ENG-P22009-R1-TIS redlines.pdf Markup Summary

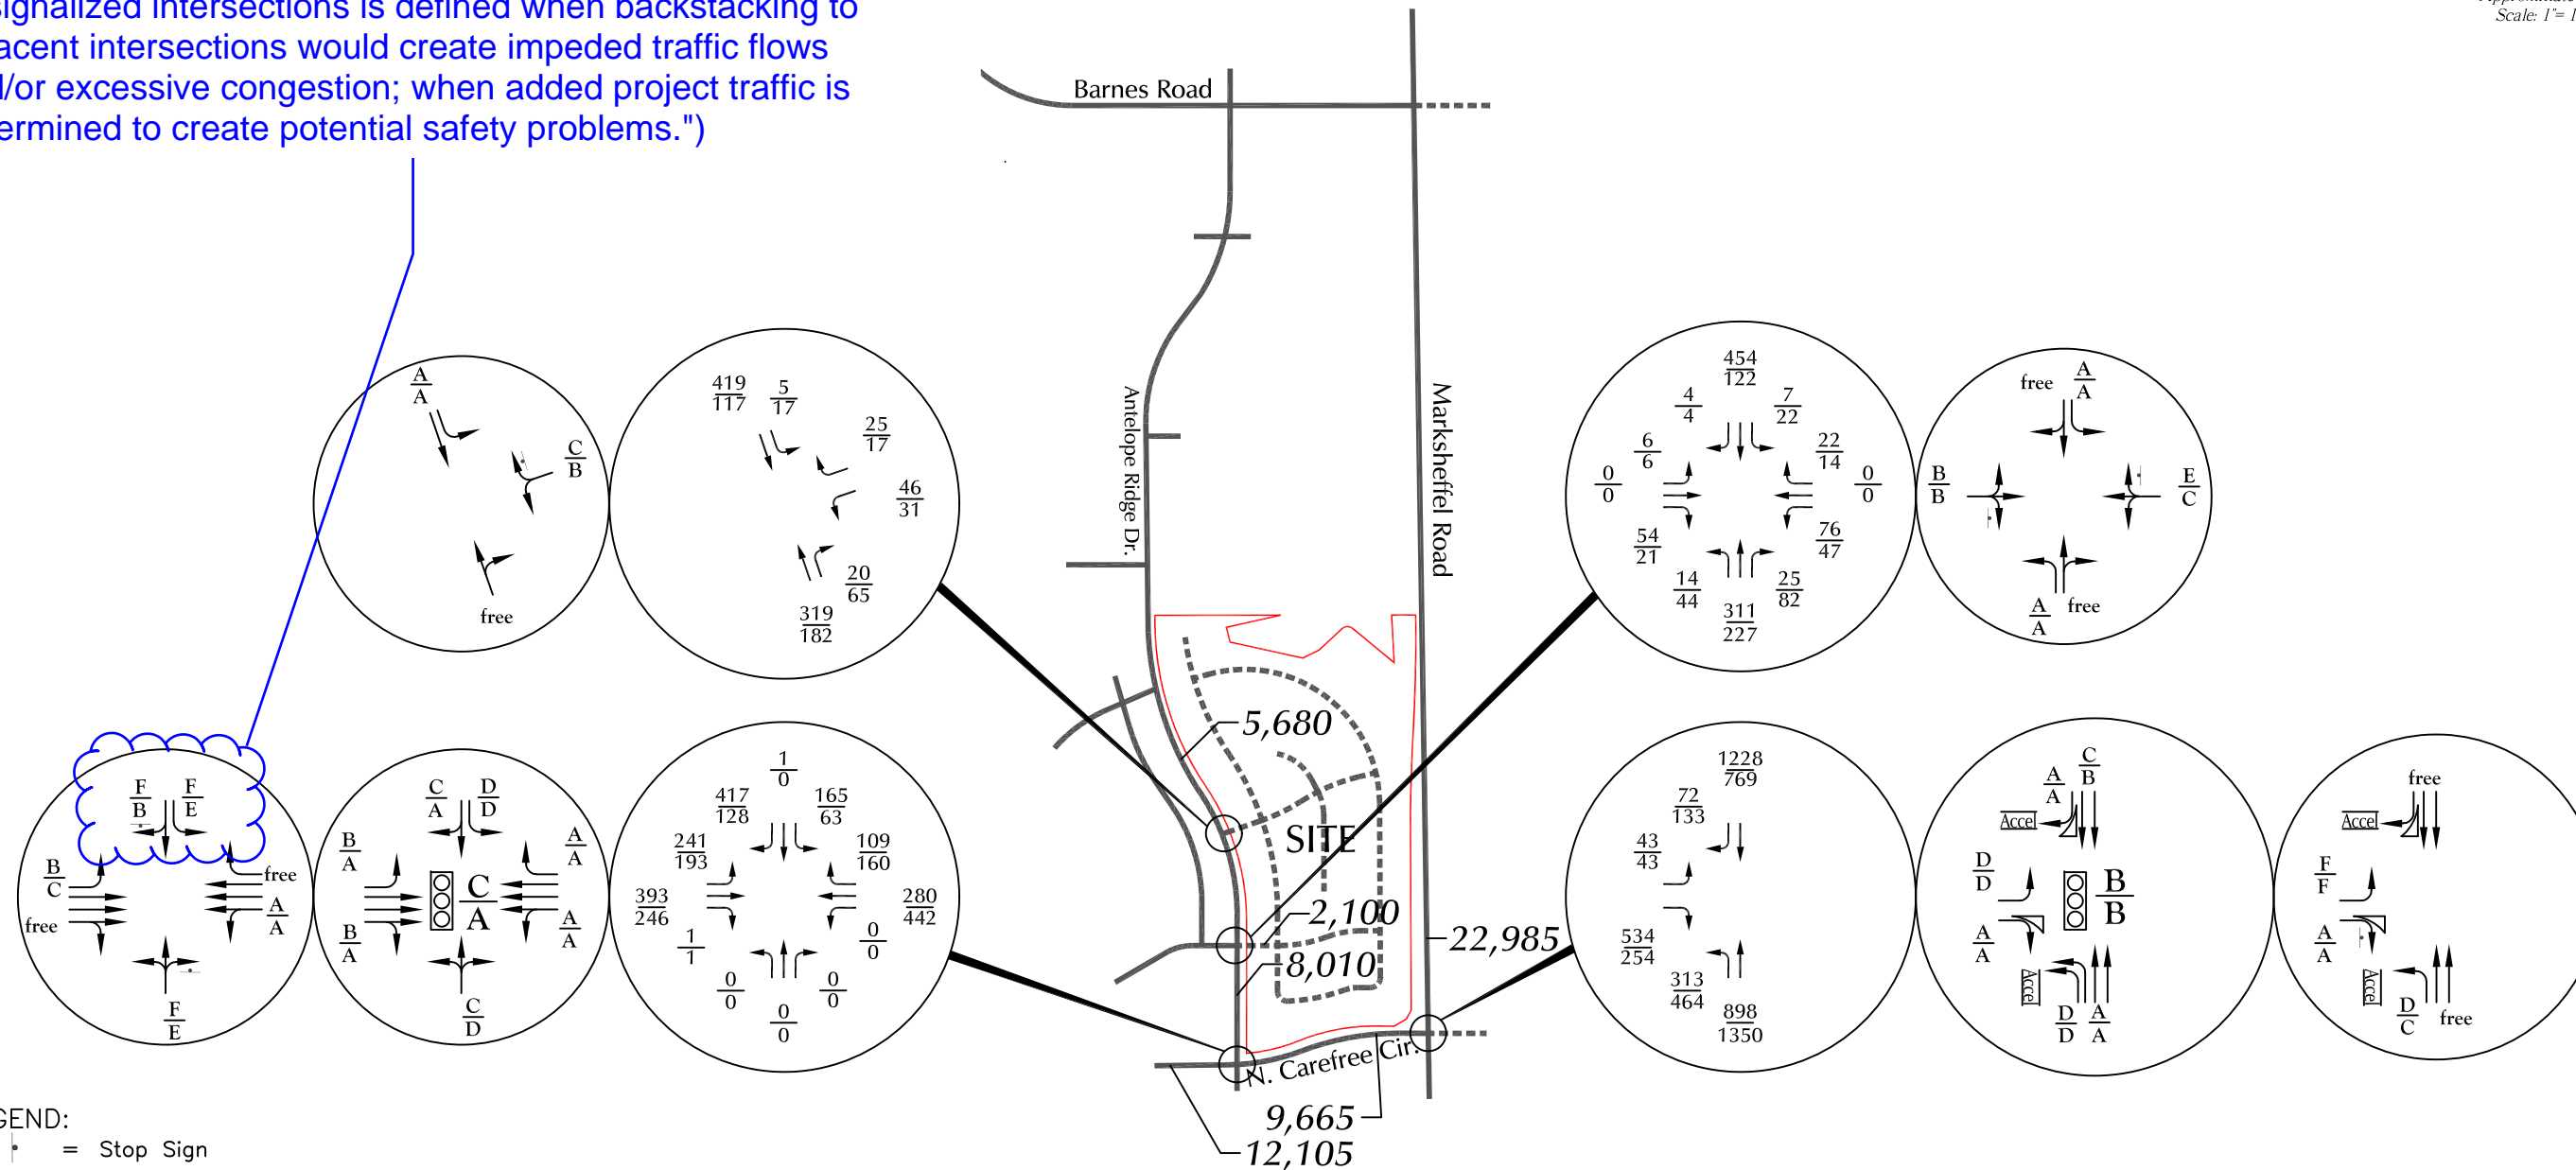
Address significance of project impact ("Significance for unsignalized intersections is defined when backstacking to adjacent intersections would create impeded traffic flows and/or excessive congestion; when added project traffic is determined to create potential safety problems.")
